# PLANNING AMENDMENT

| <b>SITE ADDRESS DETAILS</b><br>19 LANGWITH GARDENS<br>HOLBEACH                                                  |  |                                                                                                                                                     |  |

| <b>FULL DESCRIPTION OF DEVELOPMENT OF CURRENT APPLICATION THAT THIS AMENDMENT RELATES TO</b>                                                                                             |  | SINGLE STOREY REAR EXTENSION                                                                        |         |

Drg No 5561 / 2

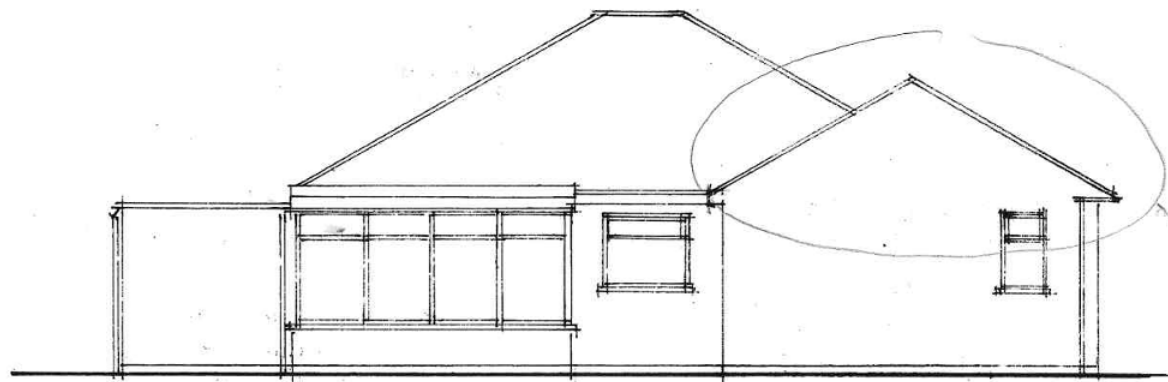
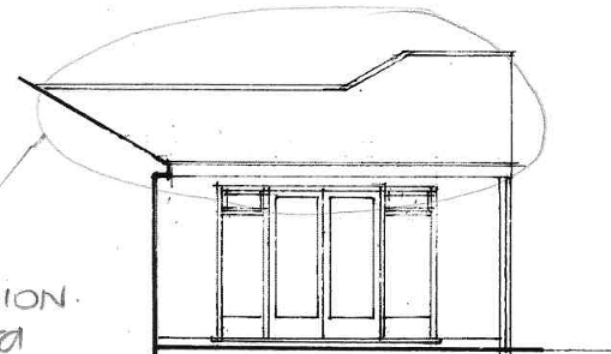
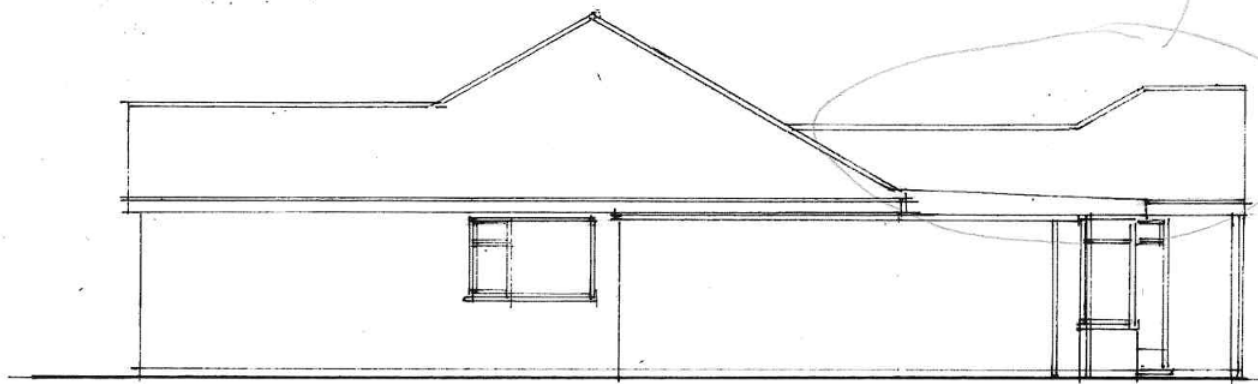
| State details of amendments proposed. (Give a full detailed list of the changes, and also mark these clearly on the accompanying plans. Only the changes listed here will be considered) |  | REAR & SIDE ELEVATIONS CORRECTED IN LINE WITH FRONT ELEVATION<br><i>Pitched roof not flat roof.</i> |         |
